Application No: FP/133/21/HH
Site Address: 33 Poulner Close Felpham PO22 8HN
Description of works: Erection of single storey front, side and rear extensions and detached annexe

Thank you for your internet representation made on 21st July 2021 which has been recorded as an objection with the comments as follows:

EXISTING GROUND FLOOR PLAN

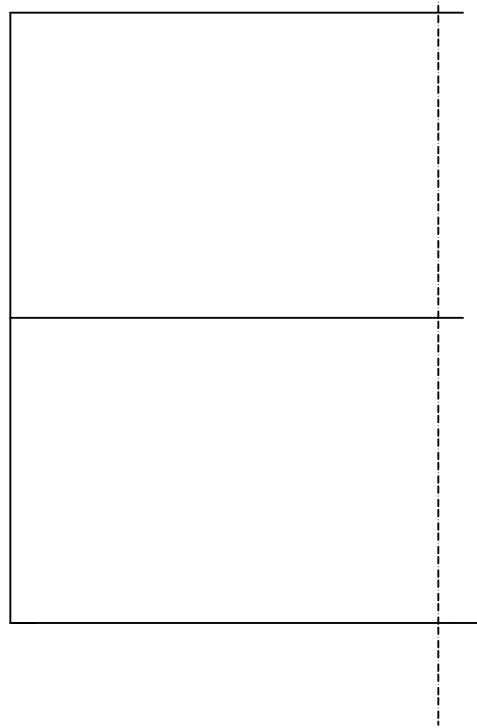
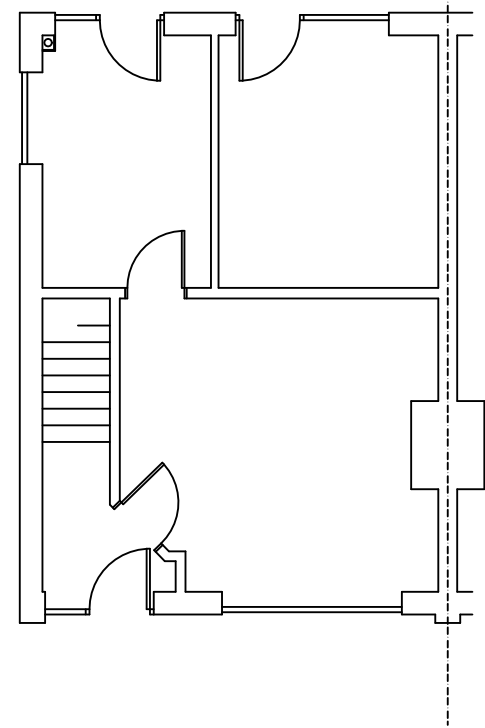
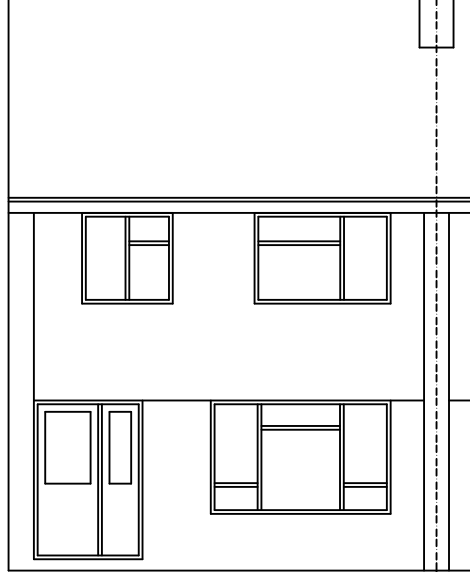
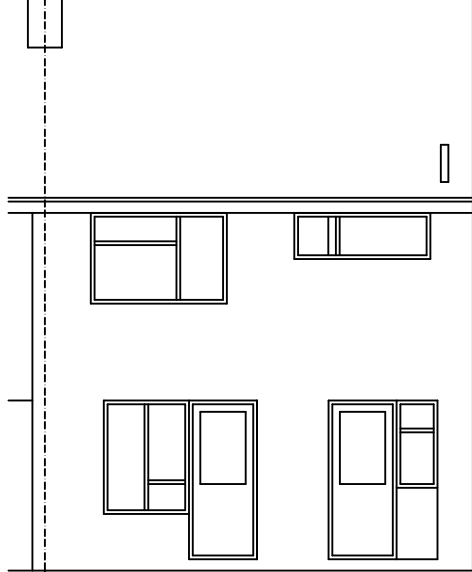
I'd like to object to the proposed plans for 33 Poulner Close, ref; FP/133/21/HH.
On the grounds that the planning notice has not been displayed anywhere outside or near the property. Thus not allowing any scrutiny.
And after briefly looking at the plans this morning. I note that there is a structure already existing on the west elevation. But it is not shown on any of the plans!
